Appendix A - Request for Additional Information Response Matrix

SSD 10424 - Trinity Grammar School

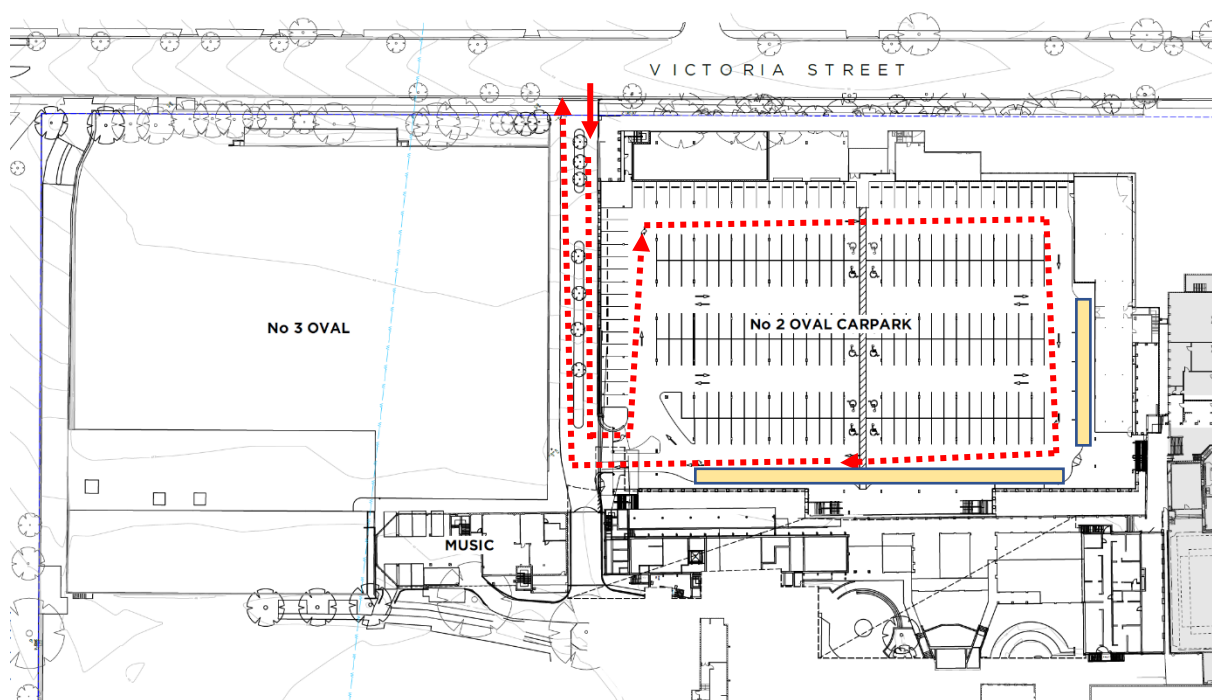
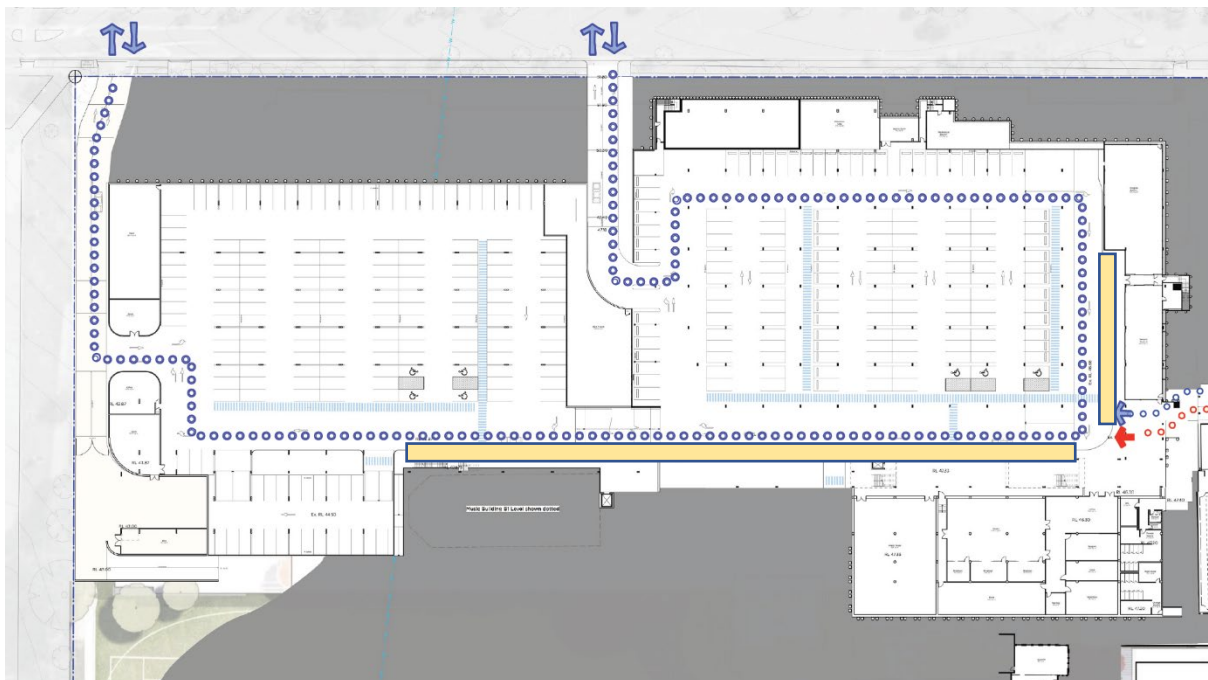
Table 1. Request for Additional Information	
Comment	Response
1. Traffic - Pick-up/Drop-off Capacity	
<p>The Department requests additional information be provided to understand the capacity and demand of the pick-up and drop off area. In this regard the Department notes that the analysis provided with the RtS indicates that under both the existing and the proposed arrangements the pickup/drop off would operate below capacity. However, the Department requires more information to substantiate the assessment as from the details provided in the public submissions and having regard to the previous findings of the NSW Land and Environment Court case (<i>Council of Trinity Grammar School v Ashfield Council [2015] NSWLEC 1086</i>), it appears likely that the current arrangements cannot accommodate the current demand, contrary to the information provided in the RtS. Therefore, the Department requires:</p>	<p>An addendum Traffic Impact Assessment has been prepared by Street Level Strategies and accompanies this application as Appendix B.</p>

Table 1. Request for Additional Information	
Comment	Response
c) consideration of impacts on queue lengths as a result of other vehicles accessing the site to park.	Refer to Appendix B for details on the consideration of impacts on queue lengths as a result of other vehicles accessing the Site to park.
The Department notes that the school has increased student numbers from 1500 (as per the last consent consent) to 1655. The traffic analysis should compare the situation between current lawful operation of 1500 students and the proposal for 2100 students.	An addendum Traffic Impact Assessment has been prepared by Street Level Strategies and accompanies this application as Appendix B .

<p>a) detailed information based on surveys and data collection to demonstrate how the existing and proposed demand has been calculated. The Department notes the number of vehicle trips is very different from data provided in the original traffic assessment, and the increase in demand (82 AM trips and 45 PM trips) is inconsistent with the traffic assessment which provides that the proposal would generate an additional 196 student vehicle trips in both of the peaks, the vast majority of which would be pick-ups / drop offs.</p>	<p>As addressed in Appendix B, the additional 196 student trips and the additional demand for +82 AM trips and +45 PM trips for the pick-up and drop-off, as they are two (2) different metrics.</p> <p>Traffic generation refers to all trips that are generated by the development which has been assessed as 196 additional student trips.</p> <p>Pick-up/drop-off metrics relate to the demand for pick-up and drop-off as a proportion of the car park traffic which is itself a proportion of the traffic generated.</p> <p>Refer to Appendix B for further detail.</p>

<p>b) detailed information to demonstrate demand in the 20 minutes immediately before the AM bell and 20 minutes immediately after the PM bell, noting that peak demand is not spread over an hour but is usually concentrated over a very short timeframe. Where demand results in queuing on Victoria Street, an analysis should be provided of any change in queue lengths and time frame for the on-street queue to clear as a result of the revised design and increased student numbers.</p>	<p>Refer to Appendix B for further detail.</p>

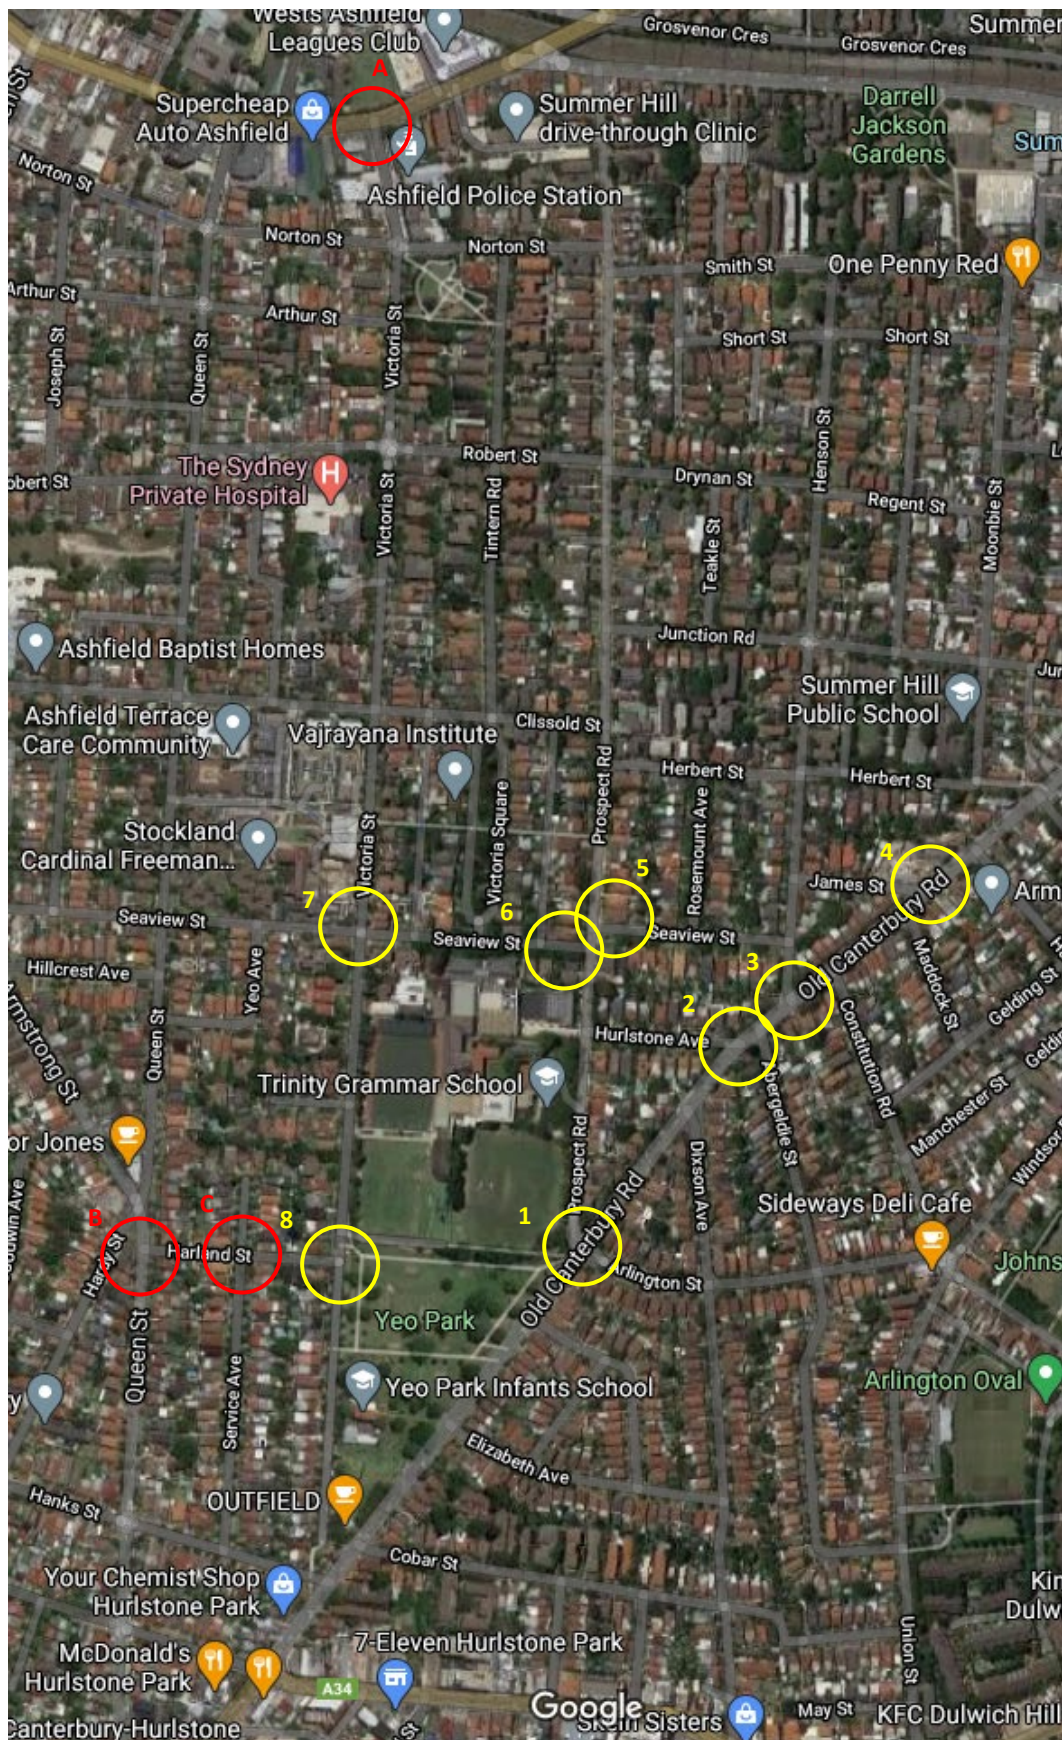
2. Traffic - Operation of Intersections	
The traffic assessment indicates that the majority of vehicle trips associated with the school use would travel either via Queen Street / Harland Street or Victoria Street / Liverpool Road, however no assessment has been provided of the impacts of the proposal on these intersections. Therefore, the Department requests that:

b) further assessment of the impacts to the operation of the intersection of Harland Street / Service Avenue.	
Additionally, the analysis should compare the situation between a current lawful operation of the school (1500 students) vs the proposal for 2100 students. Where appropriate, consideration should be given to any mitigation measures to offset the traffic impacts of the proposal.

a) further traffic assessment of the impacts to the operation of these intersections be provided,	<p>The intersections previously modelled under the assessment (including those identified as part of the SEARs) are intersections that any traffic to and from the school must travel through.</p> <p>The Department has requested further assessment of the following three (3) intersections:</p> <ul style="list-style-type: none"> ▪ A - Victoria Street/Liverpool Road (Hume Highway); ▪ B - Queen Street/Harland Street; and ▪ C - Harland Street/Service Avenue. <p>The DPIE RFI indicated <i>the traffic assessment indicates that the majority of vehicle trips associated with the school use would travel either via Queen Street / Harland Street or Victoria Street / Liverpool Road.</i></p> <p>The traffic assessment is based on the existing trip distribution captured in the data collected in October 2019. This distribution shows that 40% of the trips are to/from the north along Victoria Street, and 35% of the trips are to/from the west along Harland Street.</p>

Table 1. Request for Additional Information	
Comment	Response
	<p>As part of the traffic assessment, the intersection with Harland St and Victoria St was modelled and found to operate at a Level of Service A in both peaks across existing and future scenarios. Given this is the intersection that all traffic from or between Service Avenue or Queen Street will pass through and is closest to the school, it will bear the greatest impact. In the event the intersection at Victoria Street/Harland Street was operating at a poor level of services, further consideration and modelling of nearby intersections would have been undertaken to assess the broader impact of the traffic distribution. However, as the level of service for the Victoria Street/Harland Street intersection was good, additional assessment was not deemed to be necessary.</p> <p>Additionally, Harland Street is less than 200 metres in length between Queen Street and Victoria Street, therefore if there was significant congestion at either the Queen Street or Service Avenue, this would impact on the operations of Harland Street/Victoria Street.</p> <p>In relation to the Victoria Street/Liverpool Road intersection, the intersection is located approximately 840m to the north of Seaview, and requires vehicles to travel through three (3) other intersections prior to reaching it. Previous modelling of the intersection at Victoria Avenue/Seaview Street, which vehicles travelling to/from Victoria Street/Liverpool Road, would pass through, shows that it operates at a Level of Service A in both the existing and future modelling scenarios.</p> <p>Whilst it is acknowledged 40% of the school's traffic travels to/from the north, there are additional opportunities for traffic to disperse through other intersections, and the total additional vehicles per hour is less than 100. Therefore, it is considered unlikely that traffic associated with the school would have any impact on the operations of the Victoria Street/Liverpool Road (intersection).</p> <p>Refer to Appendix B for further detail.</p>
